**MIKE CAUSEY**  
INSURANCE COMMISSIONER & STATE FIRE MARSHAL

October 21, 2022

BCOM 2302-0007

**RE: The Springs of Ballentine  
Hectors Creek, NC – Harnett County**

THE SPRINGS OF BALLENTINE
 40 RAWLS CLUB RD.
 FUQUAY VARINA, NORTH CAROLINA
 FIRE ALARM SYSTEM

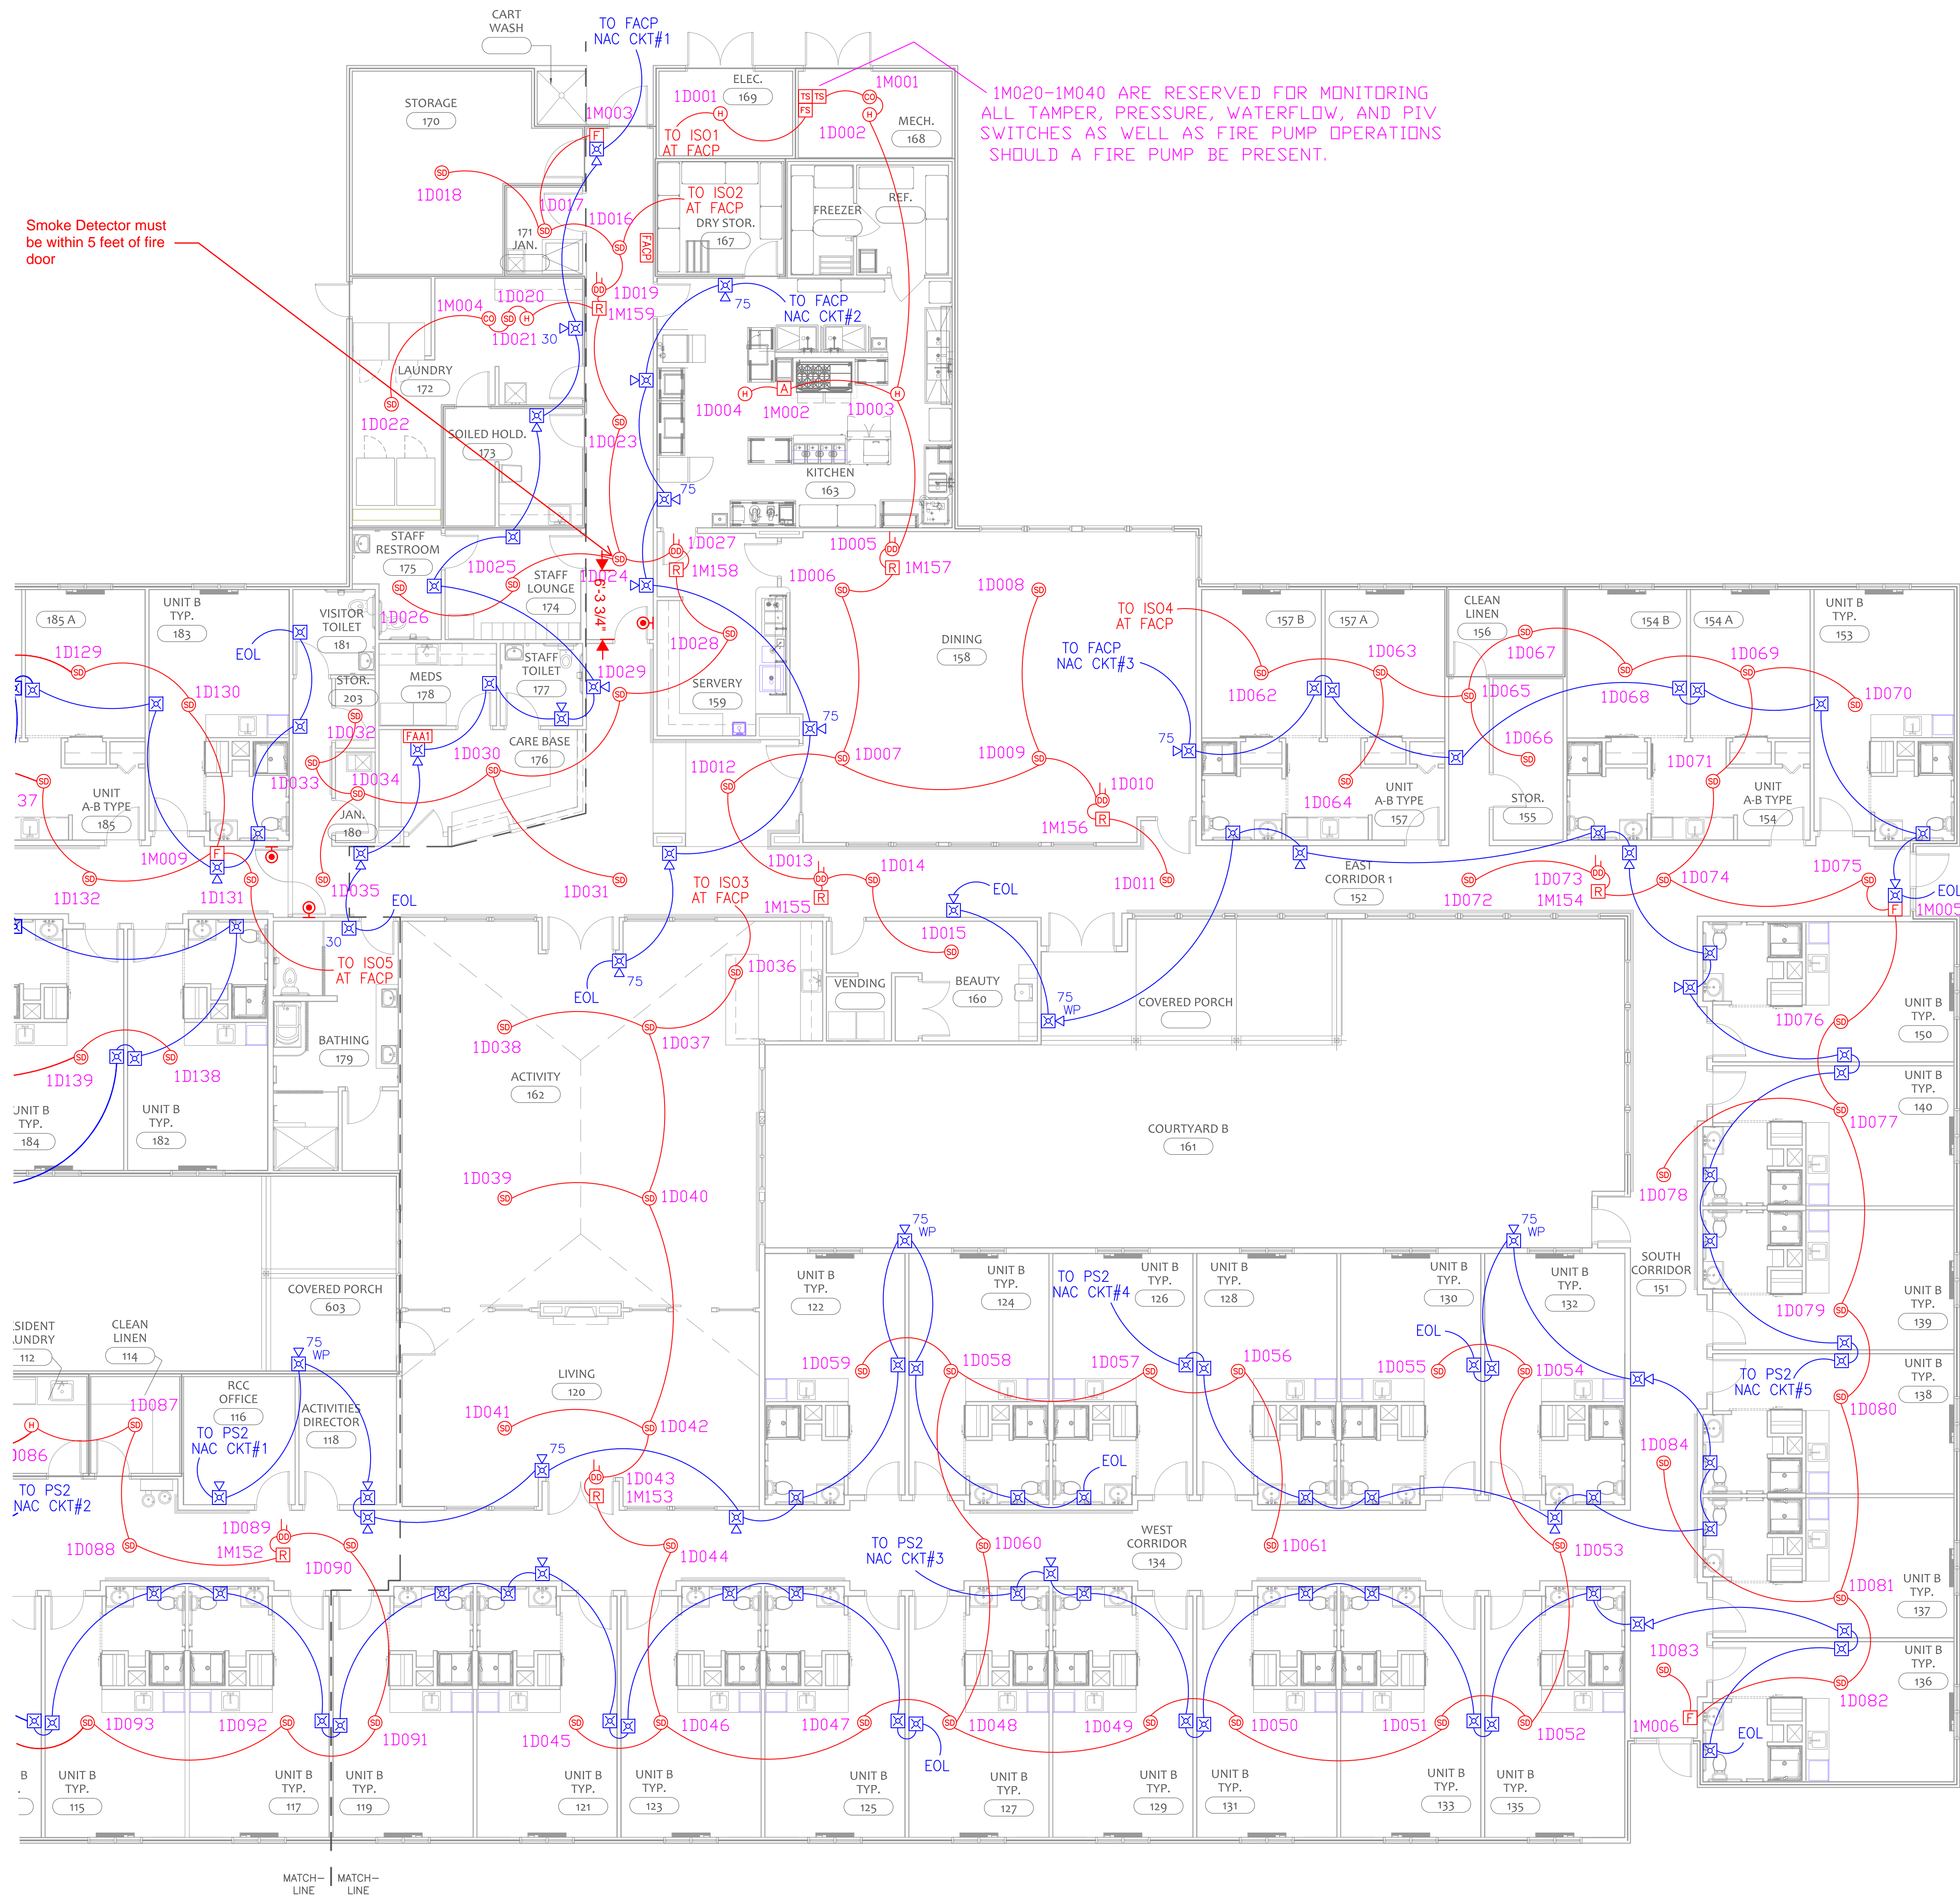
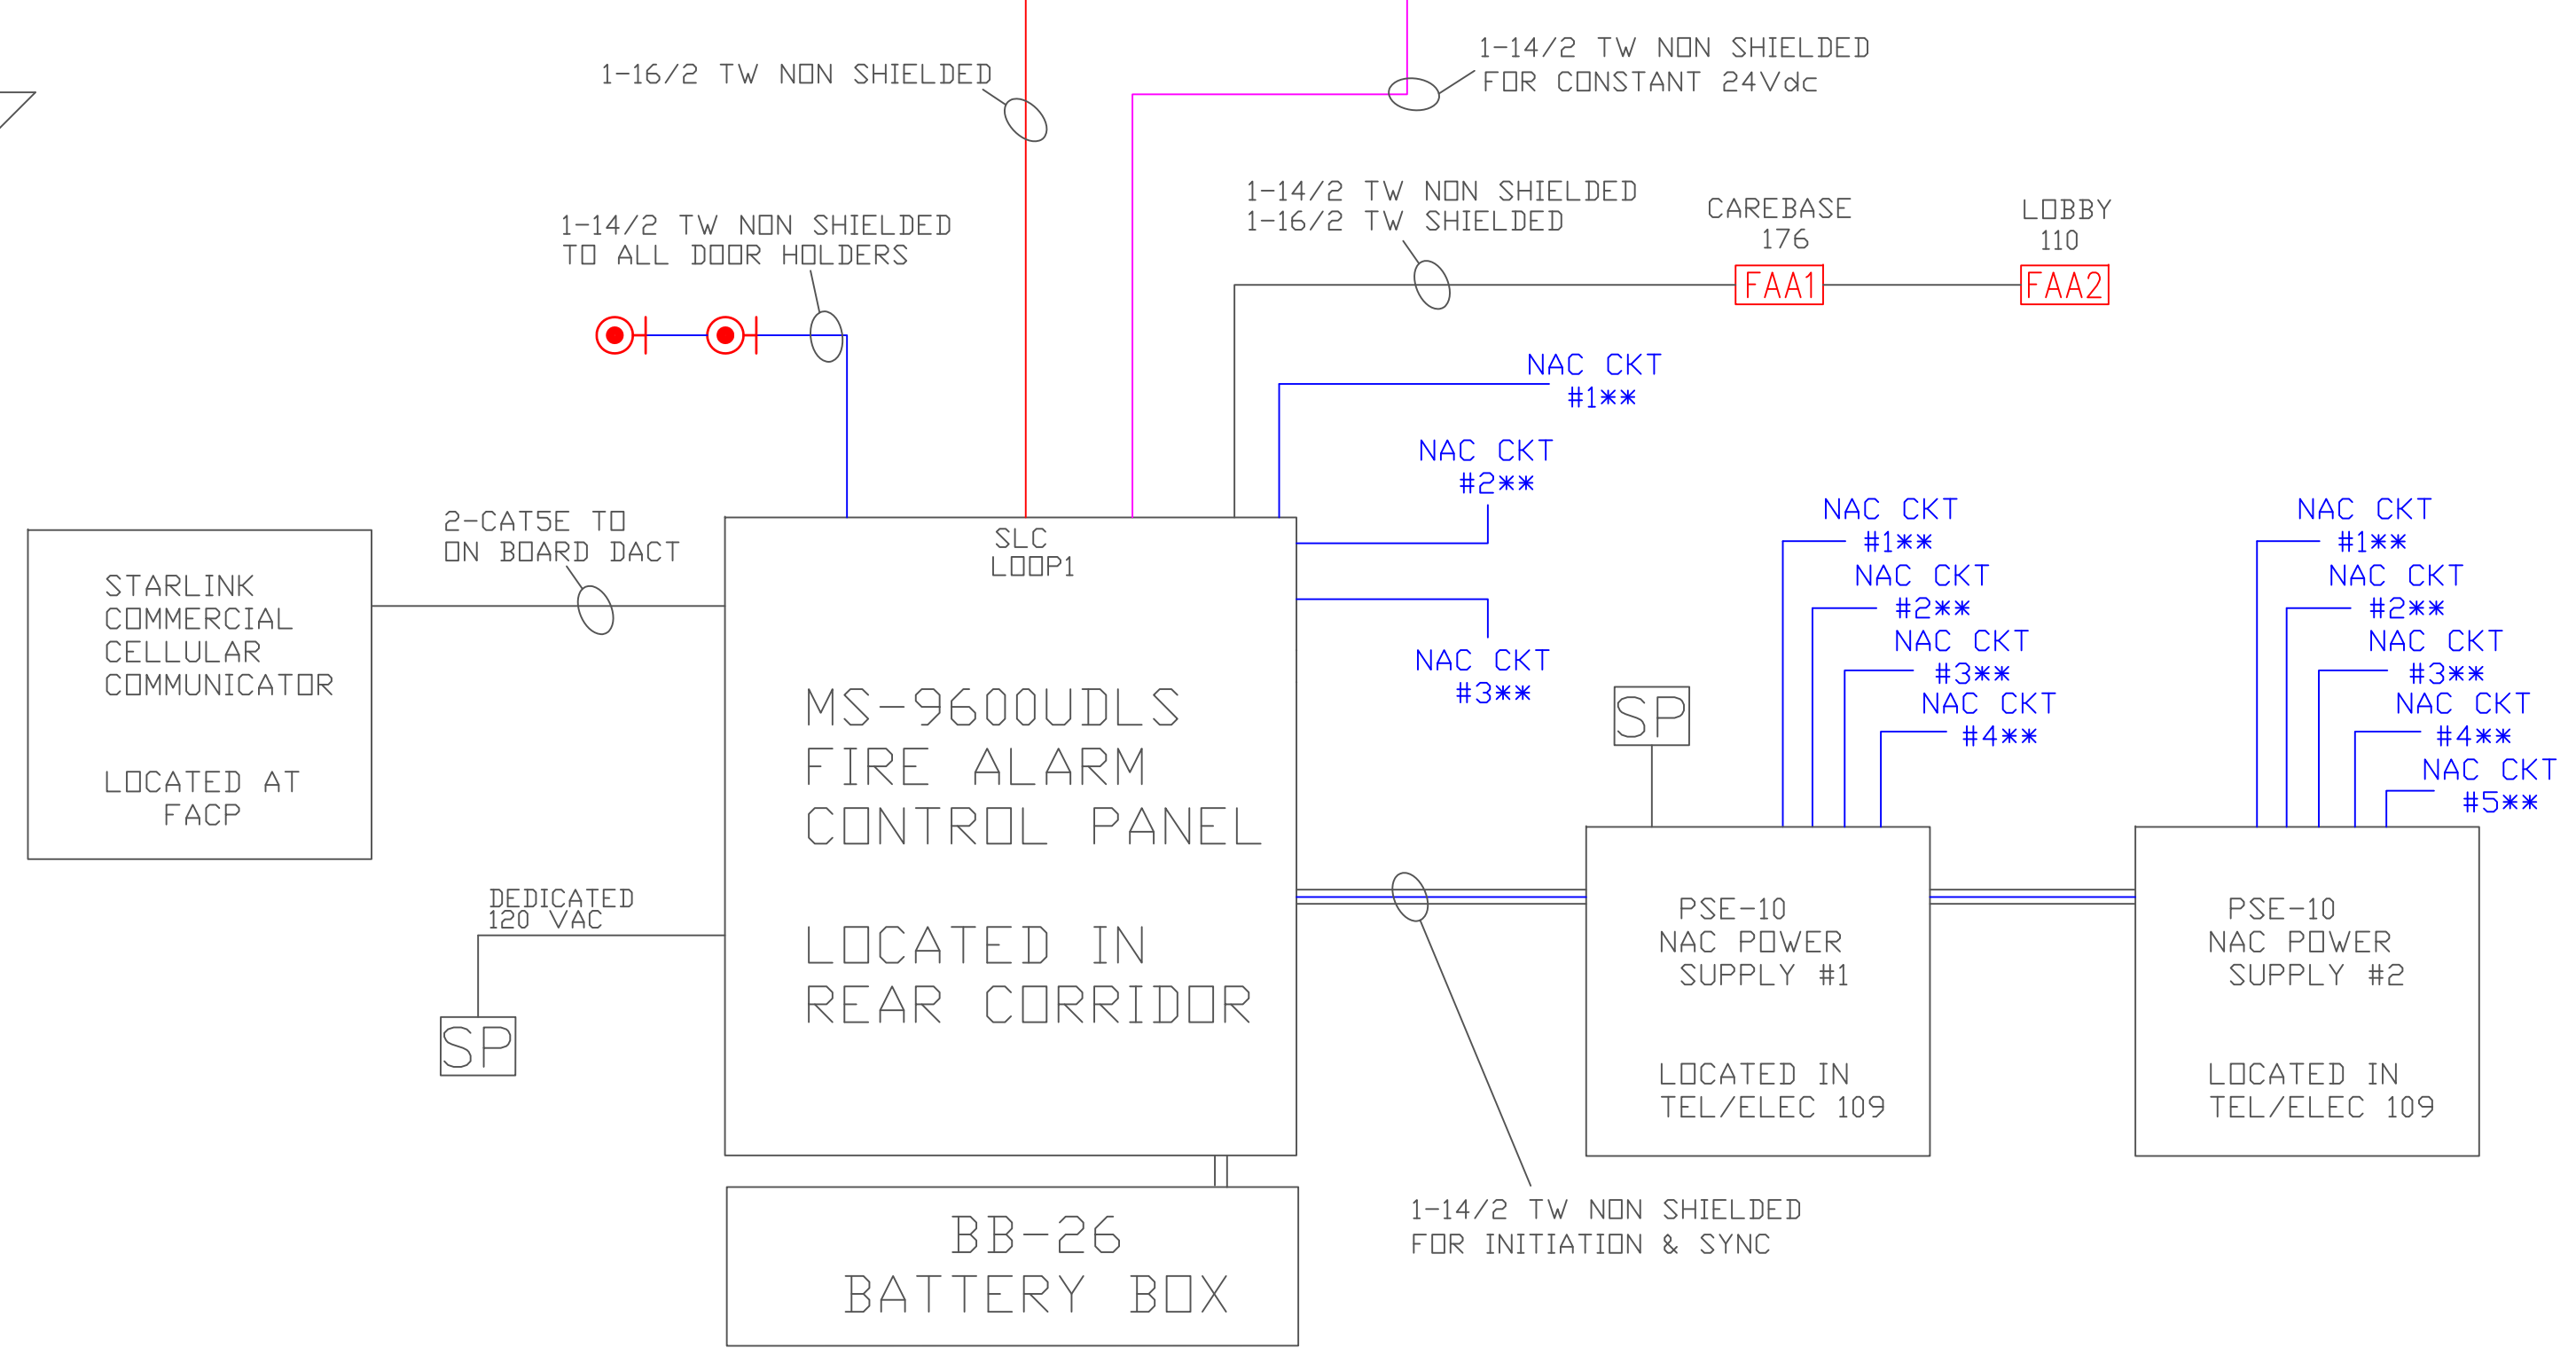
46. Page FA101 – Front entry fire alarm remote annunciator will require protection at the panel, if it has control functions. 2018 NC Fire Code section 907.4.1

47. Fire Alarm sheets - No duct detectors locations were found. Provide locations of each.
48. Circuit directories shall reference the 2020 NC Electric Code to include specific emergency and exit light circuits per 700.12 (f) and NC Fire Code 605.3.1. A note, an asterisk or EM (or similar)
